Application No: K/16/21/HH
Site Address: Sea Lodge 7 Coastal Road Kingston BN16 1SJ
Description of works: Internal alterations to existing dwelling. Demolition and replacement of existing rear extension with new single storey extension and first floor terrace above with external staircase. Replacement of main roof and 4no. new dormers with windows. Replacement roof tiles to single-storey projections on North elevation. Proposed rear single storey minor extension to garage to form entrance lobby. Alterations to external facade of house and replacement windows and doors throughout. Associated landscaping to suit.

Thank you for your internet representation made on 24th May 2021 which has been recorded as an objection with the comments as follows:

Drawing
Existing Elevations

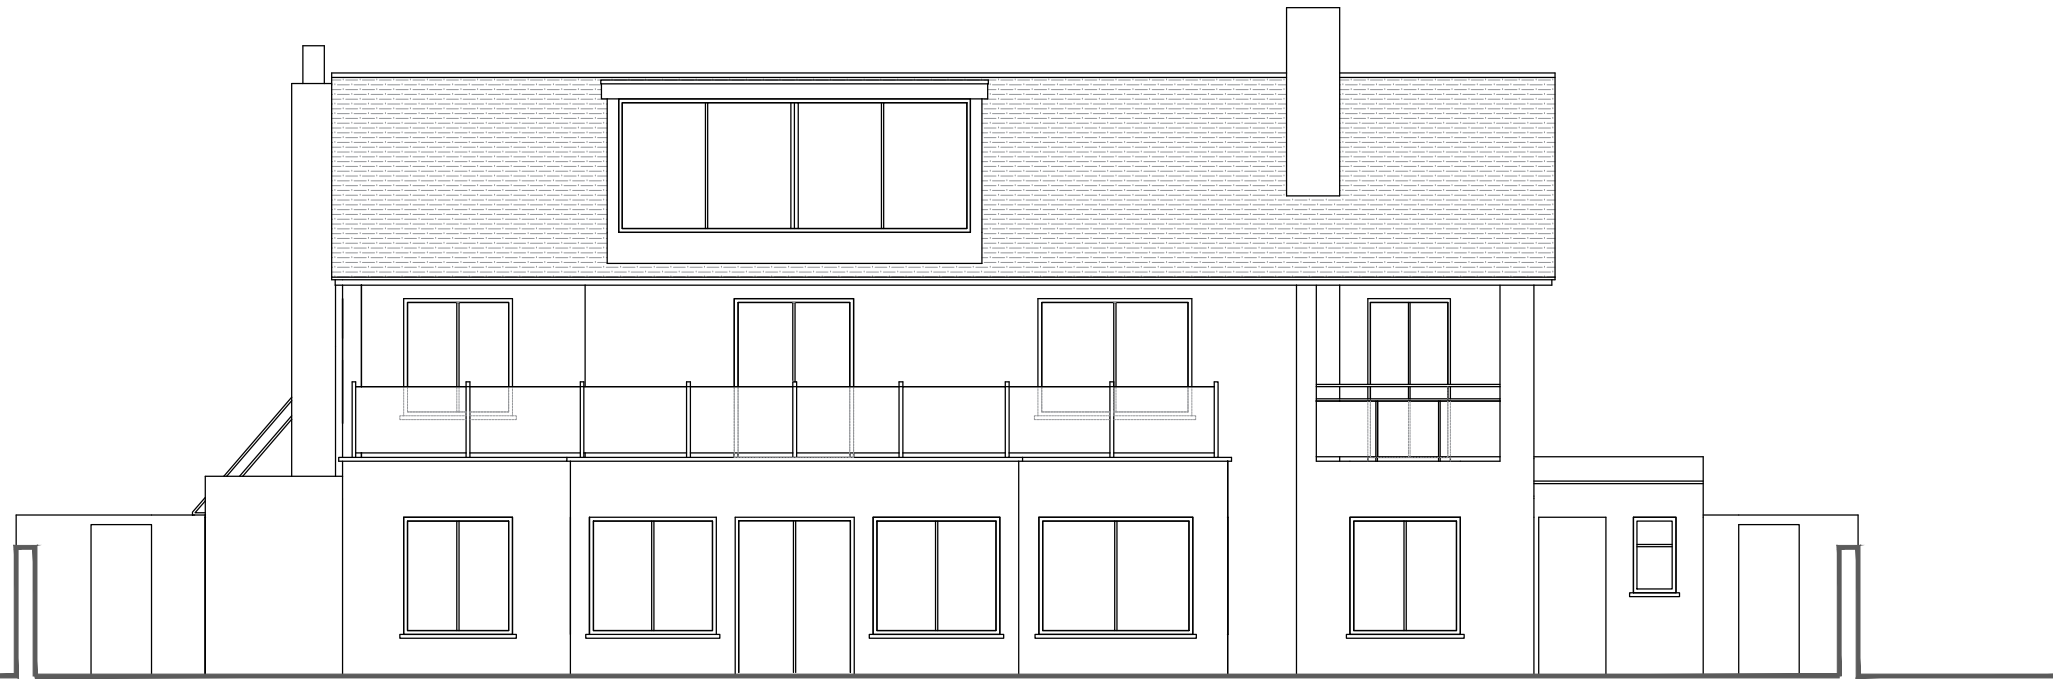
1. The proposed height of the new roofline appears to add an additional 1 meter to the existing elevation which would be above the neighbouring coastline properties.
2. The proposed balcony extension would now infringe our privacy as this would look directly into a downstairs bedroom.
